**From:** Rael, Rudy E.  
**Sent:** Thursday, September 29, 2016 9:43 AM  
**To:** 'David Soule (david@riograndeengineering.com)'  
**Subject:** Matthew Dr. Storage

Based upon the information provided in your submittal received 9/13/16, the above referenced Grading and Drainage plan dated 9/9/16 cannot be approved for Grading Permit or Building Permit until the following comments are addressed:

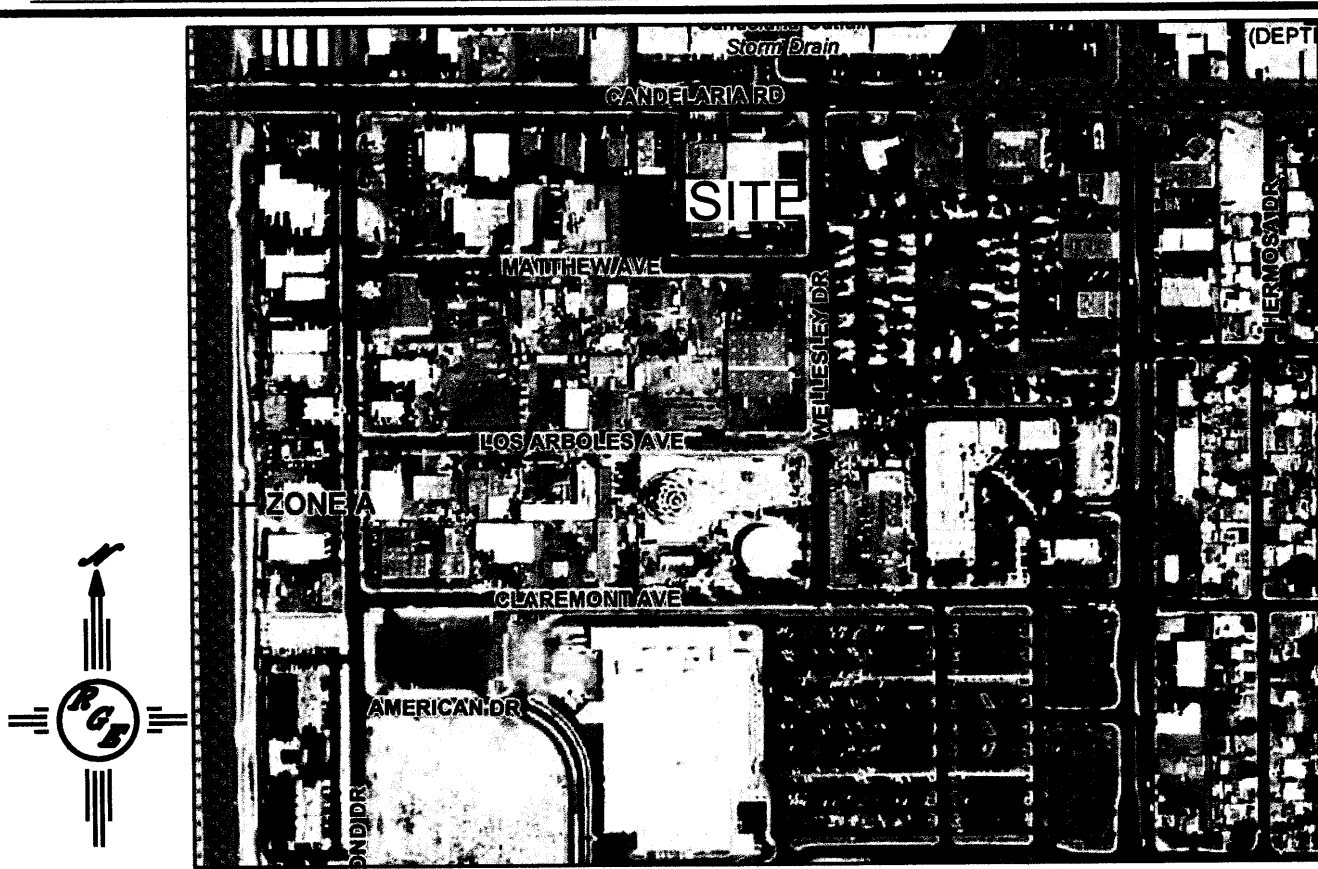
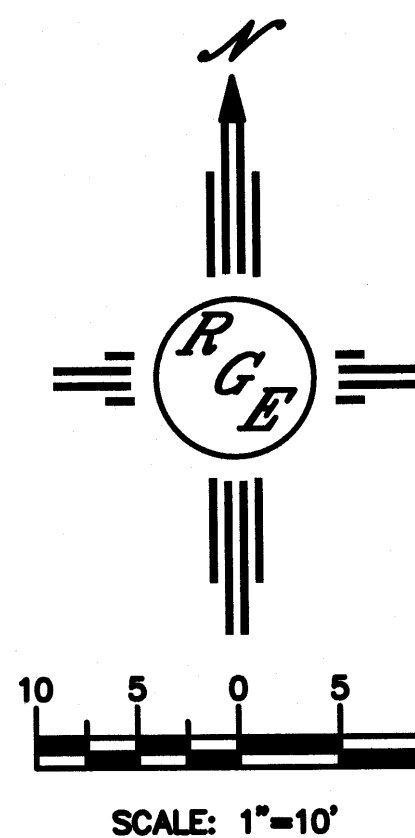
- Enlarge the drainage calcs or provide on a separate sheet with the proper font size. Once submitted the calculations will be checked.
- Provide spot elevations outside the new buildings.
- Statement on sidewalk culvert, add extend passed property line 1 foot.
- Are the landscaping areas new? Is there a curb at the edge of pavement? Is the entire site paved?
- Provide a note in the SO-19 notes stating, to contact Jason Rodriguez at 235-8016 for the sidewalk culvert inspection before and after pouring the concrete.
- Provide a notes stating, The curb stone for the sidewalk culvert must be removed from joint to joint, no cutting.
